Planning Application 2009/1143, dated 1st September 2009.

Erection of 2-story office block, on land off Duke Street, Hoyland.

**SITE PLAN
WITH**

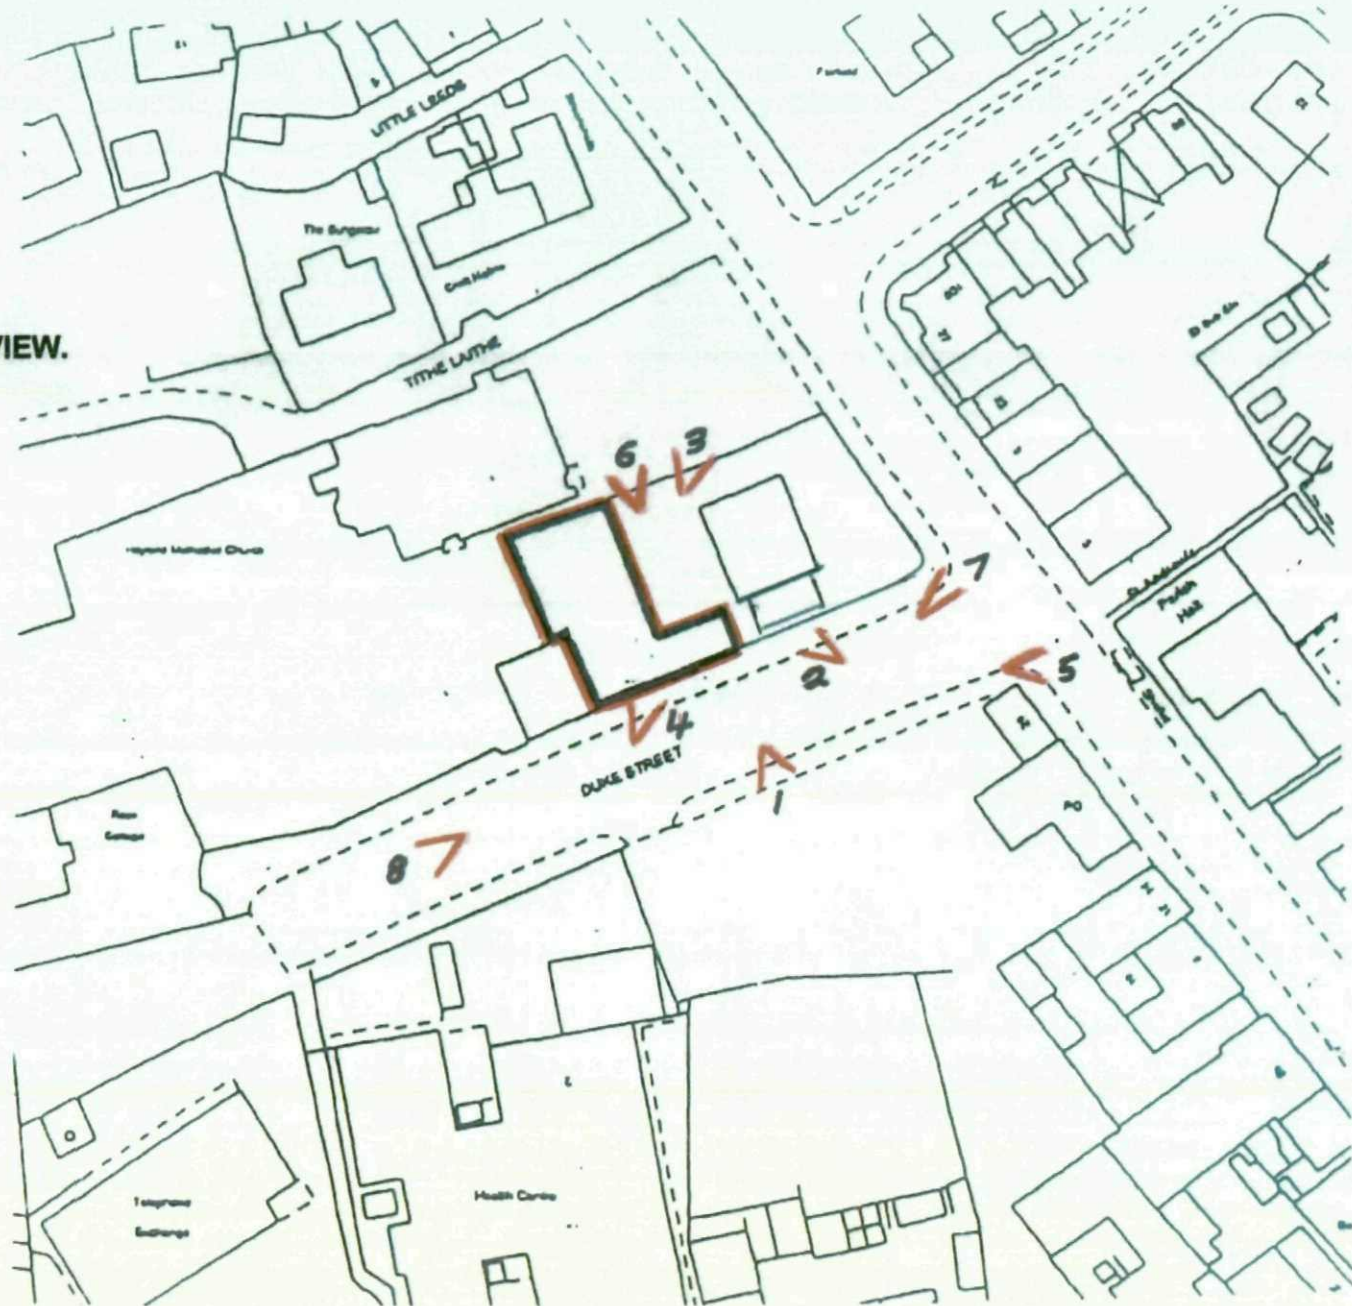
- The reference made, as “the relationship of the building with adjoining uses” being considered as unacceptable requires to be explained further as we fail to recognise the meaning.

- It can be clearly seen from our newly submitted block plan of the street plan that adjoining uses, if this is the meaning, comprises of surrounding area occupied by predominantly commercial and business.

- Our additional drawing showing the block plan of Duke Street also shows the provisions already there for car parking. It also shows the relationship of all the surrounding occupants, which clearly indicates that the development does not detract away from the surroundings but enhances the area.

- The block plan also shows that the provision of the disabled parking to the front of the site will not in anyway caused concern regarding safe access and egress onto the road.

Drawing No: 1/B.

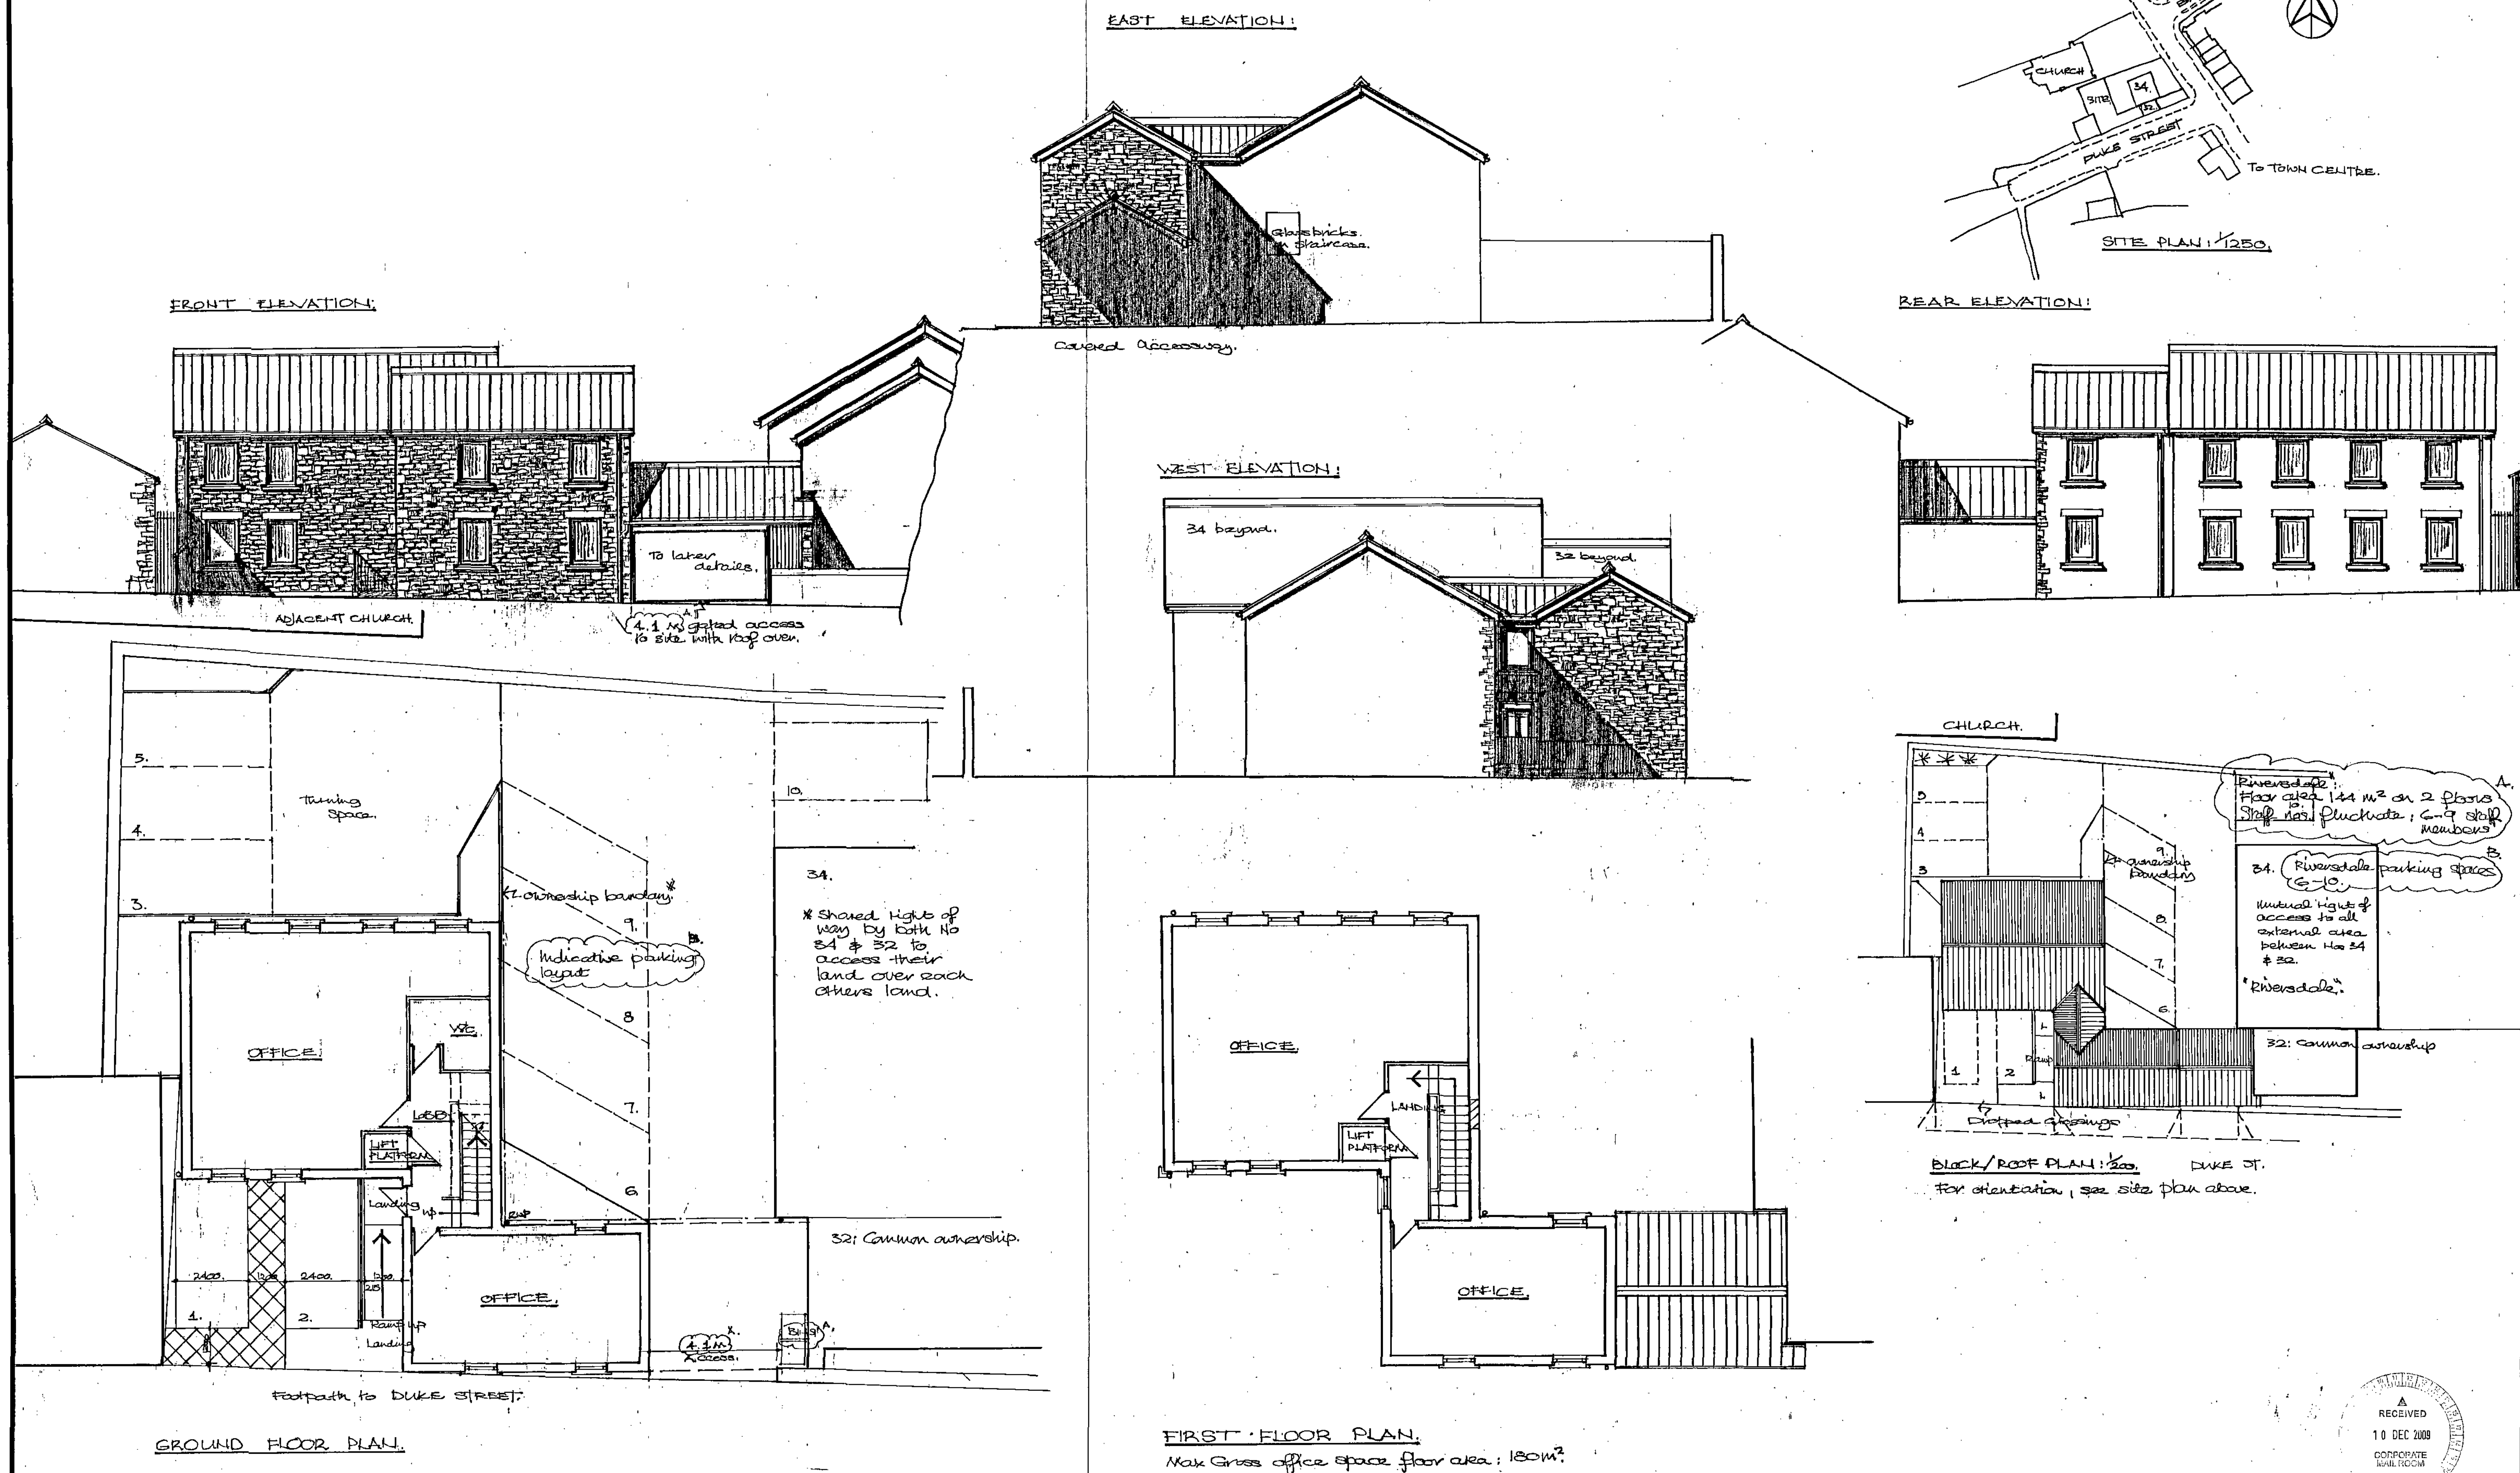
- *The re - siting of the Bin store to the front of the site.*
 - *The reduction of the entrance to 4.1m to enable the building, fronting Duke street to be slightly lengthened, thus allowing for more car parking space.*

I refer to planning application made for the office development at Duke Street. I appreciate that the plans have been amended to address initial concerns however, there still remains some issues with the proposed parking provision. The indicative parking layout to serve Riversdale identifies 6 parking bays all of which appear to be substandard in size (i.e. below 2.5m x 5m), to address this I would proposed that it is amended in accordance with the attached plan. This would result in the loss of one parking space (cumulatively) between the development and Riversdale but it would appear that Highways would not object to this.

I refer to your application made for office development at Duke Street in Hoyland. The recent amendments have now been reviewed and having discussed the development with consultees it is considered that the proposal represents an overdevelopment of the site. As such the recommendation to planning board will therefore be for refusal.

There are no objections to the redevelopment of the site in principle but it is considered that any scheme would have to be of a reduced scale to that currently proposed. The main considerations are the access and parking arrangements and the relationship of the building with adjoining uses which at present is considered to be unacceptable.

Development of the site is difficult given its modest size and it is not considered that the access and parking arrangements (on the present proposal) can be further improved above that identified on the recent amended plan. It is therefore considered that the footprint of the building needs to be reduced and sited towards Duke Street. This would remove the parking to the front (which at present have poor visibility splays) and would ultimately improve the parking and service arrangements for both the proposed development and Riversdale. It is important that any proposal can successfully accommodate suitable vehicle manoeuvring arrangements so that they can safely manoeuvre within the site and egress in a forward motion.

- Access and parking can clearly be improved from the suggested layout by Mr Kirkham and this is shown to our further revised plan.
- Given the acceptance that we require to provide a total number of 10 parking spaces for the size of the office layout and in compliance with planning document 32, this is clearly shown to our revised plan. All access and parking arrangements are now such that manoeuvring arrangements are both safe and all vehicles can now egress in a forward motion.

- However, given the comments made we have revised the layout to the front to give better visibility, but it should be noted that this particular street/highway has footpaths of 2.75metres in width (over half the width of an average car before reaching the highway) and a highway width of 10.1 metres, well in excess of the normal provision.
